June 23, 2008

From: Barbara Masberg, 6390 Cove Road, Adjacent Land Owner

Subject: Response to B&J Preliminary Plat (LP-08-21)

B & J PLAT
PART OF SECTION 7, T. 17 N., R. 18 E., W.M.
KITTITAS COUNTY, WASHINGTON
- PRELIMINARY PLAT -

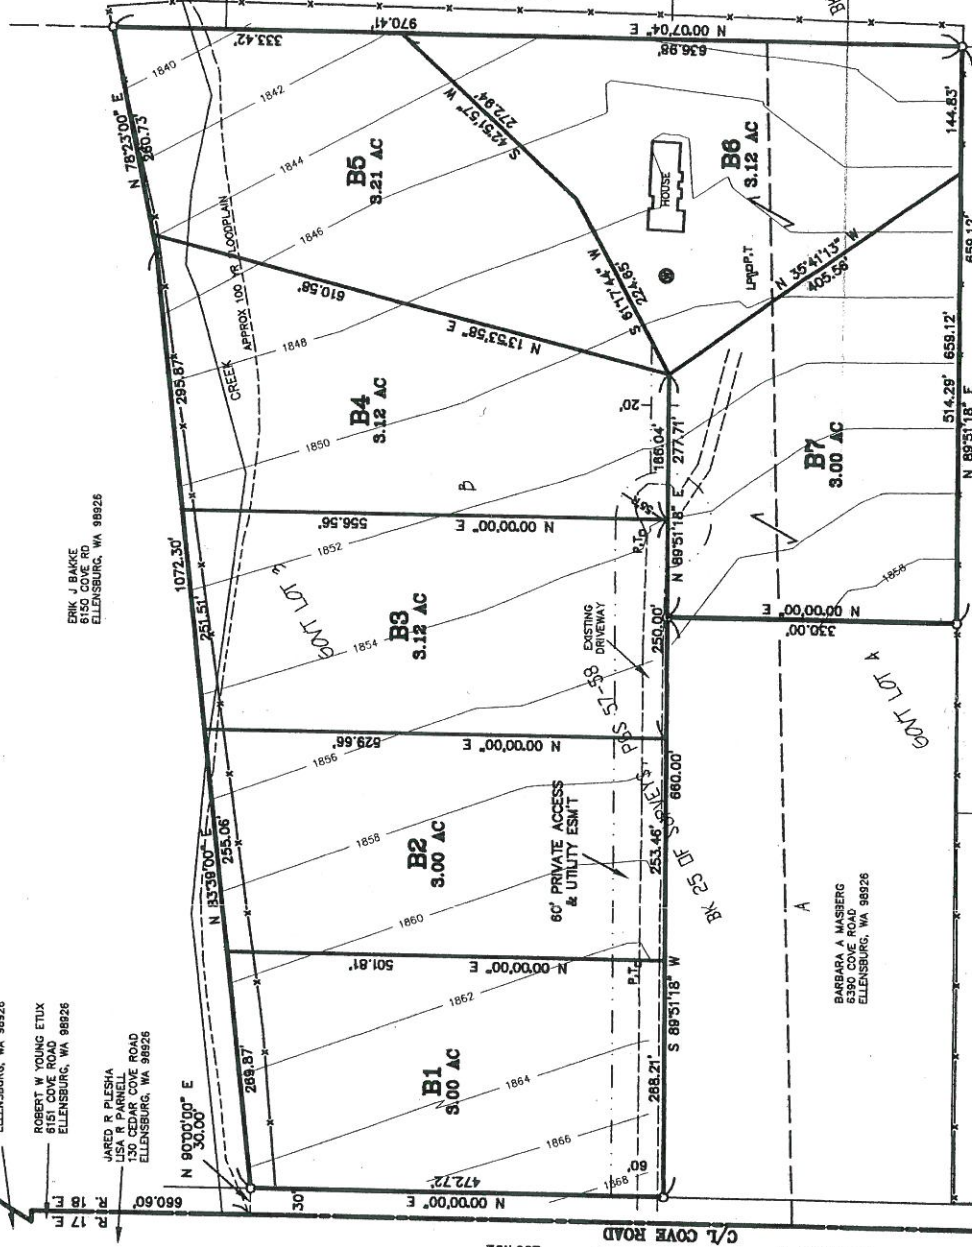
4. In August 2006, Duncan installed his driveway. He changed the traditional flow of spring water diverting it by installing a 45 degree culvert. Prior to August 2006, ground water flowed from property on the west side of Cove Road through a culvert onto the easement on the property line then onto my property, then to Duncan's finally dissipating. The flow of the water was

changed when the Duncans' constructed their driveway. There is no discussion of this ground water on the application. This water has already been diverted and further excavation and diversion will have to be done I was not informed of these changes and was told by the County when the deed was done, that this had been approved by them and not by the Department of Ecology who has jurisdiction.

5. The subdivision, according to the SEPA document would generate 70 vehicular trips per day, but indicates that there needs to be no measures or controls in place to reduce impacts. I disagree. The road for the entire subdivision is 5 feet from my property line. A severe impact with prevailing winds creating a dust cloud as each vehicle drives up the driveway. This dust cloud would blanket the immediate land with garden in which vegetables for consumption are grown as well as the area which houses poultry. This directly affects the health of the residents. Mitigation must occur in order to alleviate these issues. Minimally paving the driveway and screening or perhaps a buffer with vegetation should be established. No measures have been proposed to mitigate these problems.
